DEVELOPMENT HEARING OFFICER - HYDROLOGY SECTION
Anthony Montoya, Jr., PE, Senior Engineer | 505-924-3314 amontoya@cabq.gov

DRB Project Number: 2020-003484 Hearing Date: 01-22-2025
Project: Volcano Cliffs, Lots 2 & 3, Blk 12, Unit 3 Agenda Item No: 3

DRB Project No: PR-2020-003484 Date: 1/22/2025 Agenda Item: #1 Zone Atlas Page: E-10

Application For: SD-2024-00158 – EXTENSION OF PRELIMINARY PLAT (DHO)

CITY OF ALBUQUERQUE
 PUBLIC WORKS DEPARTMENT
 ENGINEERING DEVELOPMENT GROUP
MOJAVE SUBDIVISION
 GRADING AND DRAINAGE
 GRADING PLAN

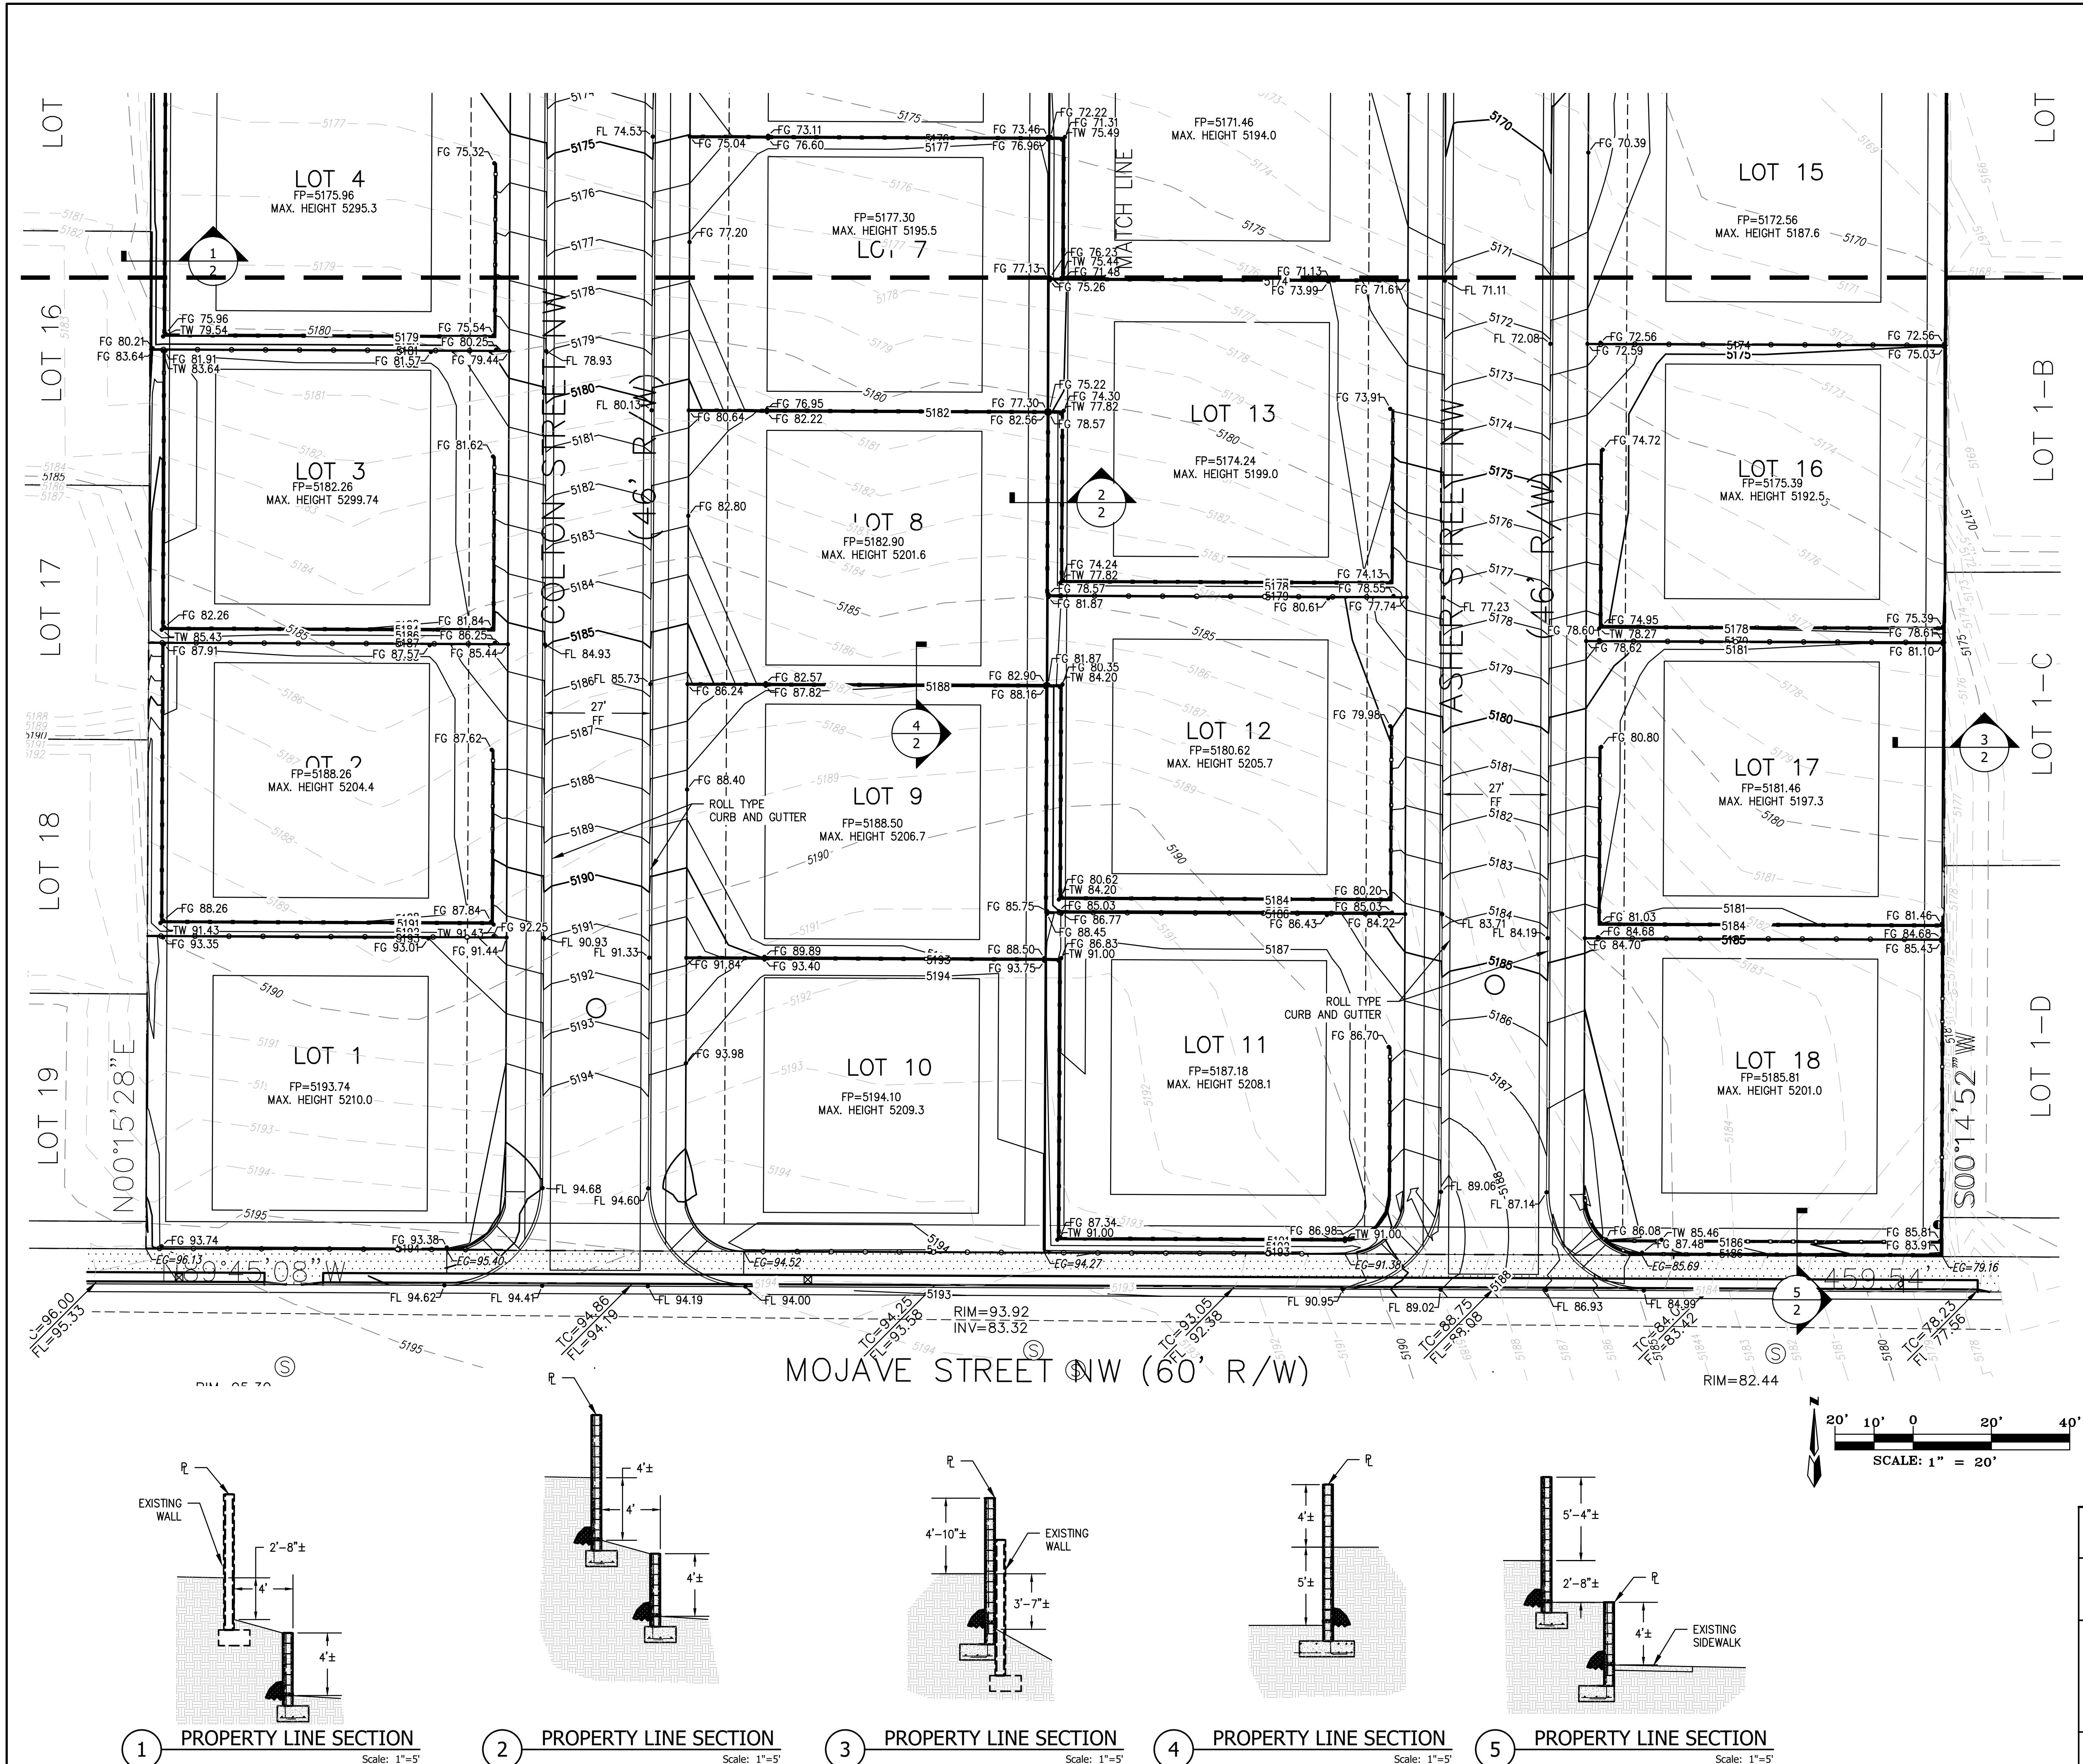
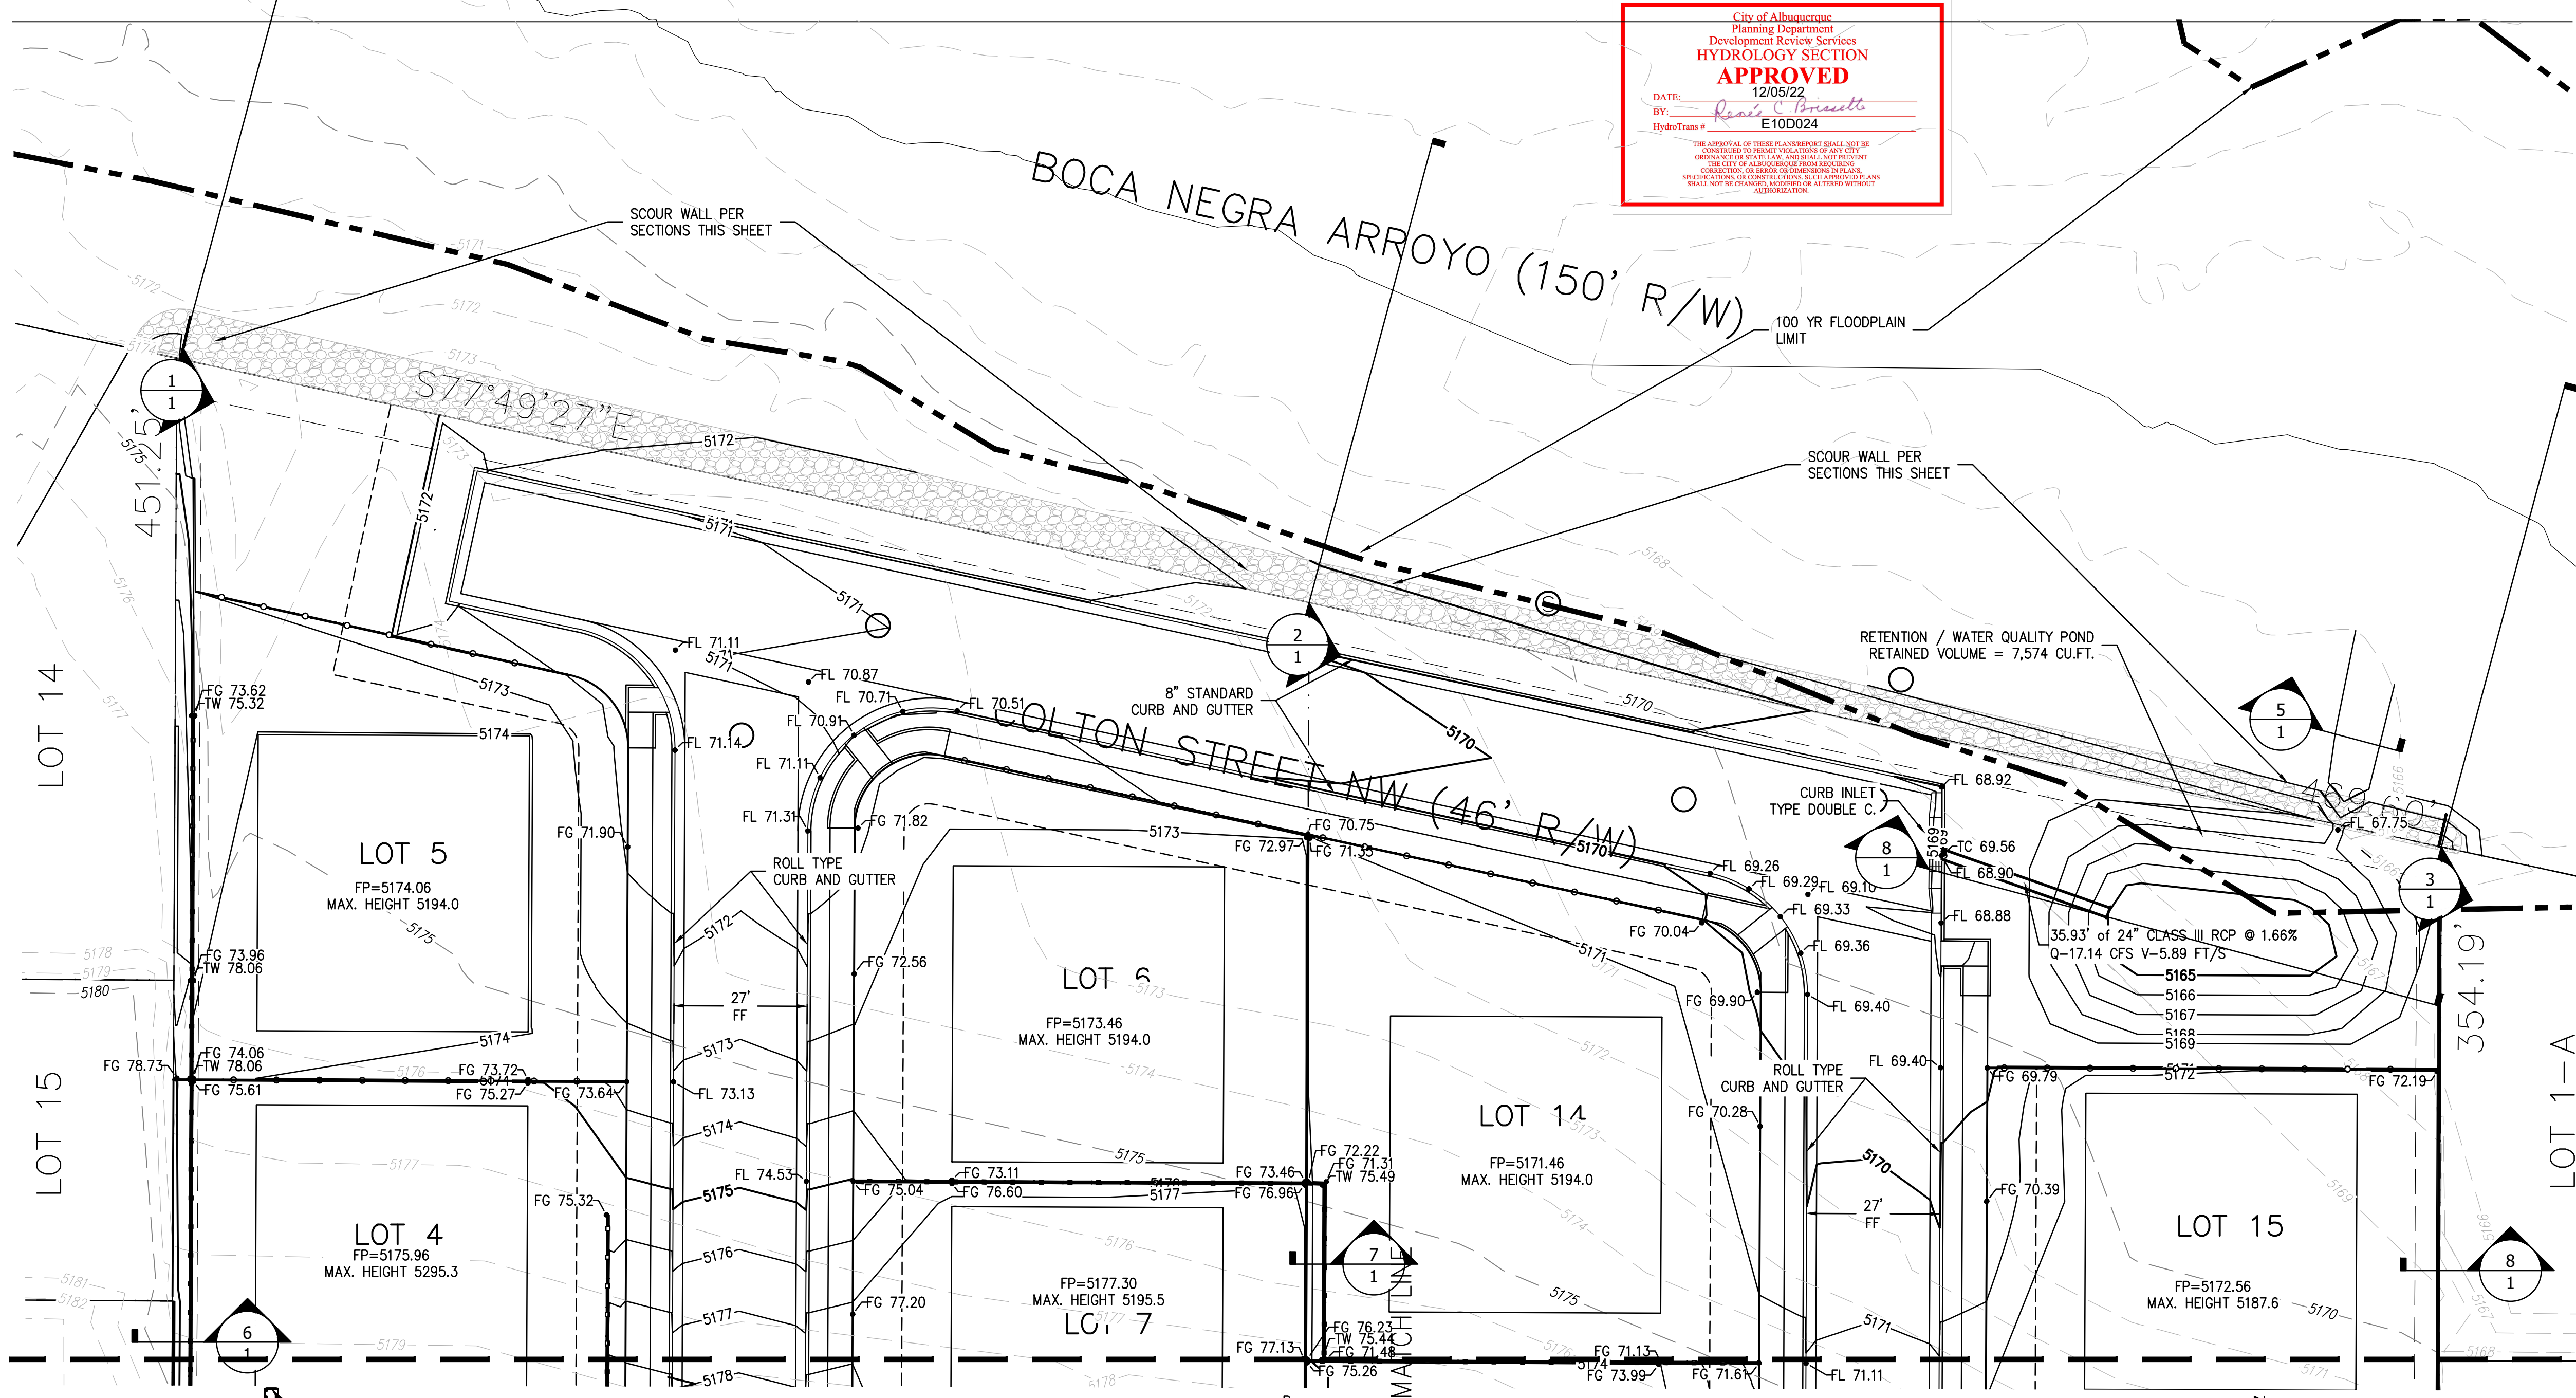
- Due to the location of the proposed pond and the existing Zone AE, Floodway, Hydrology requires an updated Grading and Drainage Plan prior to approval of Preliminary Plat or Site Plan for Building Permit.
